From: Fiona Pudge <Fiona.Pudge@sportengland.org>
Sent: 24 November 2020 11:45
To: Planning
Subject: App Ref: 3/2020/0845- Stonyhurst College BB7 9PZ - Sport England Ref: PA/20/NW/RV/56928

FAO: Adrian Dowd

Having assessed the application, Sport England is satisfied that the proposed rugby pavilion meets Exception 2 of our playing fields policy, in that:

Drawing Title:
**Proposed Oak Framed
 Rugby Pavillion**

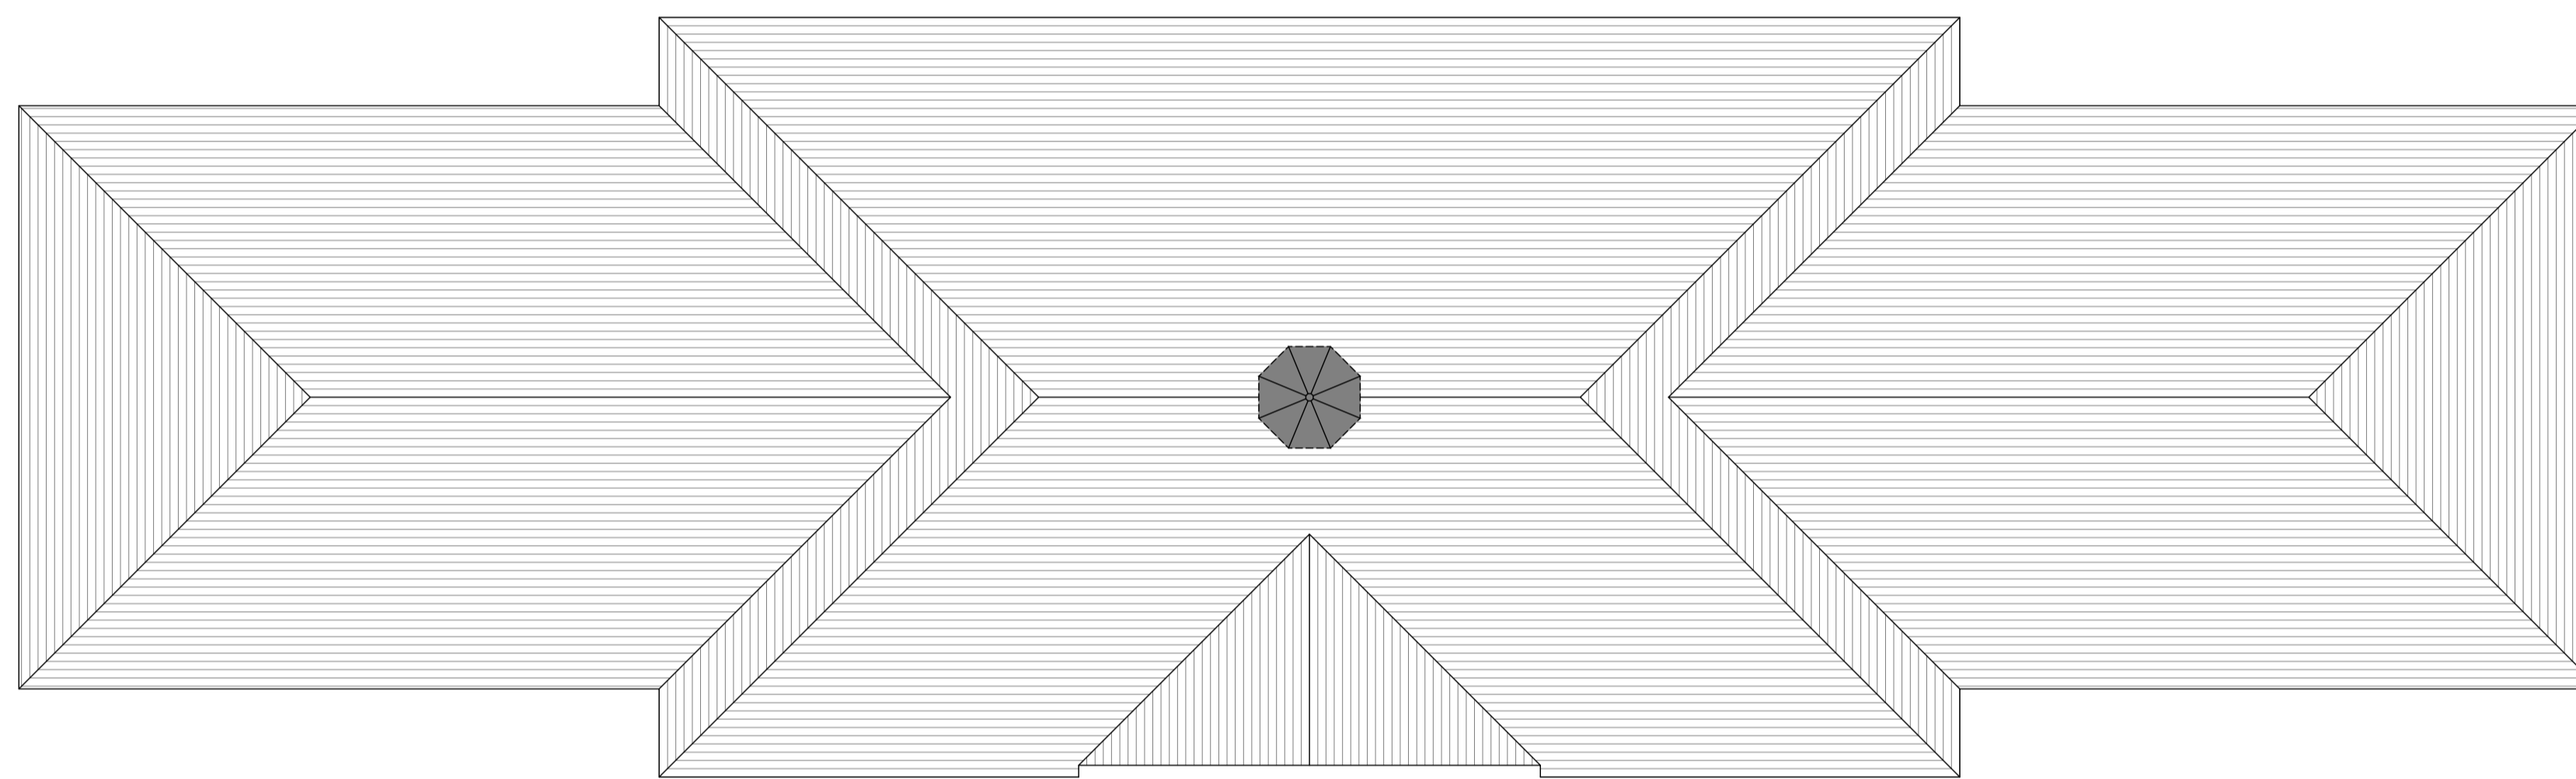
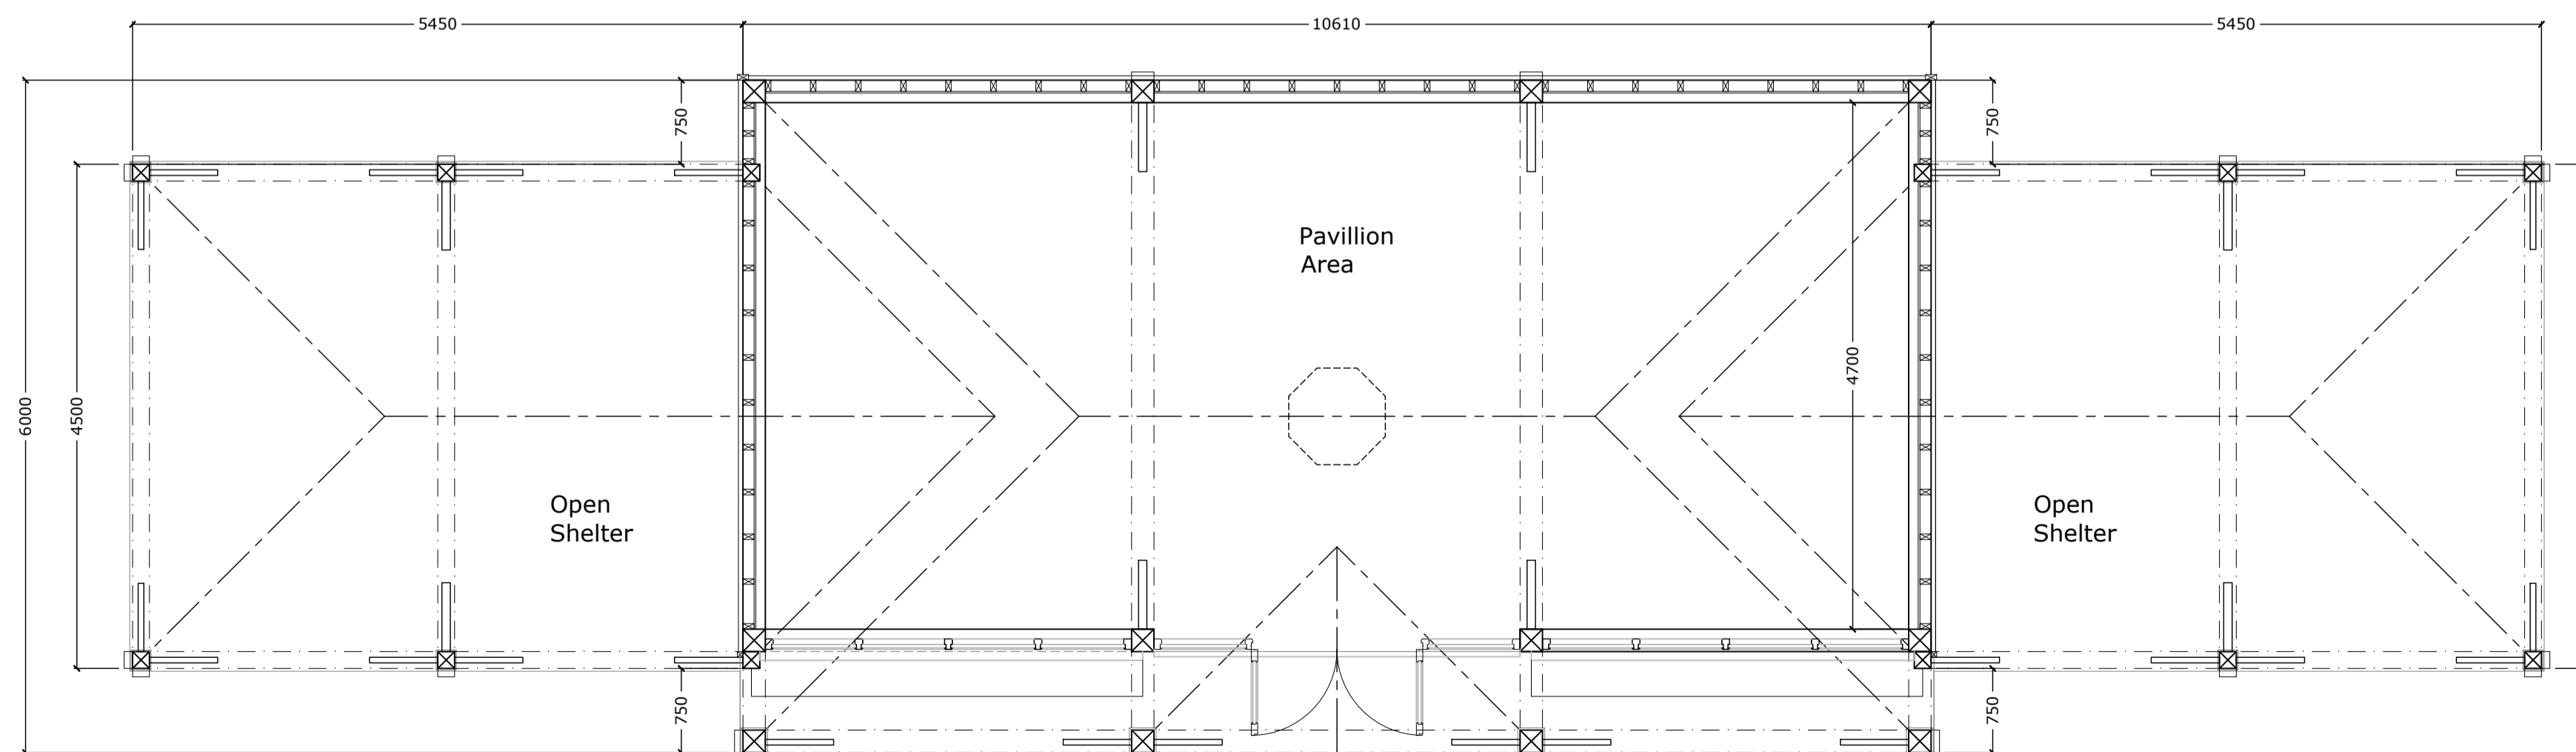
However, as an advisory note, and after consultation with the Rugby Football Union, it is felt the pavilion creates an opportunity to provide a small scale changing room for pitch users. Also as refreshments are to be provided then a toilet should be included. I understand there are changing rooms on site but that they are some distance from this pitch.
